Comment for planning application 22/02068/REM

| Location | OS Parcel 7400 Adjoining And South Of Salt Way Bodicote |
| Proposal | Reserved Matters to 14/01932/OUT: Parcels 1 and 3 for 240 dwellings - appearance, landscaping, layout and scale |

BLOXHAM ROAD

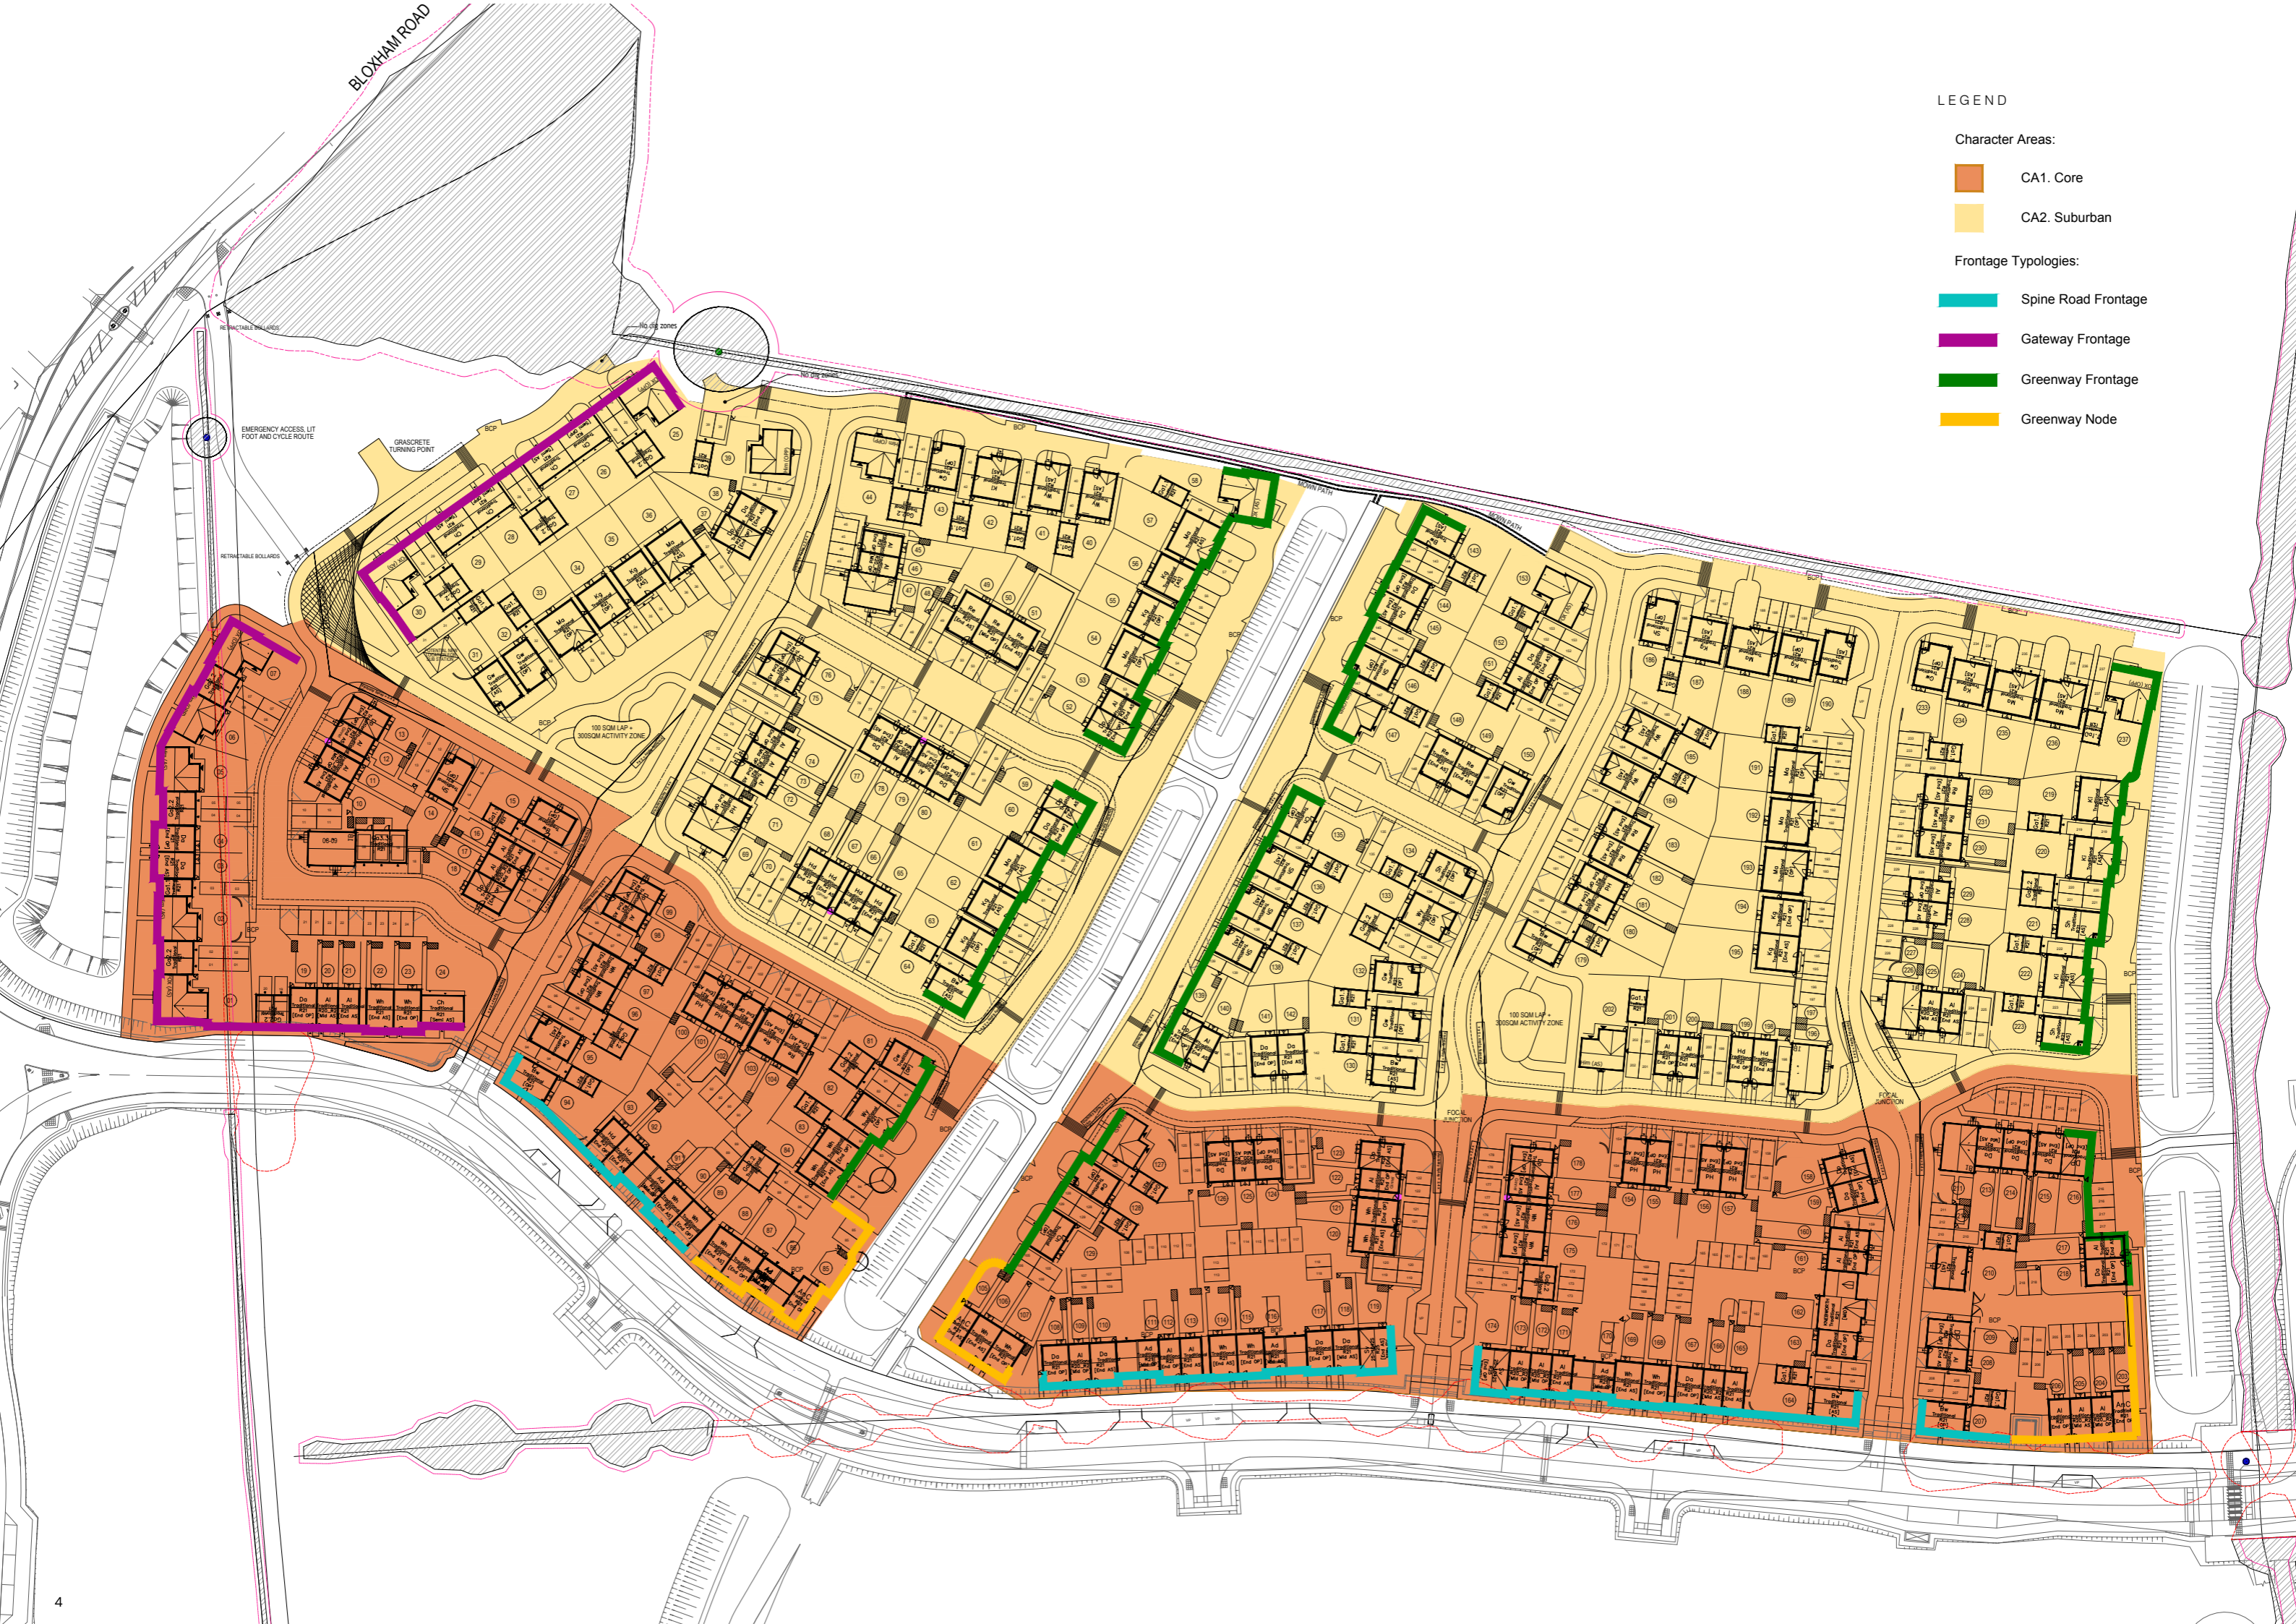
| Comments | <p>I object /comment on behalf of Banbury Civic Society : - Can it be confirmed, please, that the overall structure and composition of the development will comply with the outline permission given so long ago ? Please explain the impact of the different coloured areas shown on the plan (the significance is not clear) and also how these categories/ designs will impact on adjoining developments. It is particularly important that the Local Centre and School are not overlooked - the Centre must include a health Centre / Doctor's Surgery, as originally promised, as those currently in the Town are grossly over-subscribed to the detriment of existing and new residents.</p> <p>The limited information provided regarding the appearance and siting of the housing is unimaginative, monotonous and unexciting. It compares badly with the adjoining development. It smacks of limited effort and desire to establish a community that new residents will be proud to join. Please encourage the developer's designer to inject some interest and variety into both individual designs and layout. Remind him / her that these buildings are likely to exist for probably 100 years and therefore should provide a quality and environment that new residents will be pleased to enjoy. We already have too many undistinguished buildings amongst recent new builds.</p> |
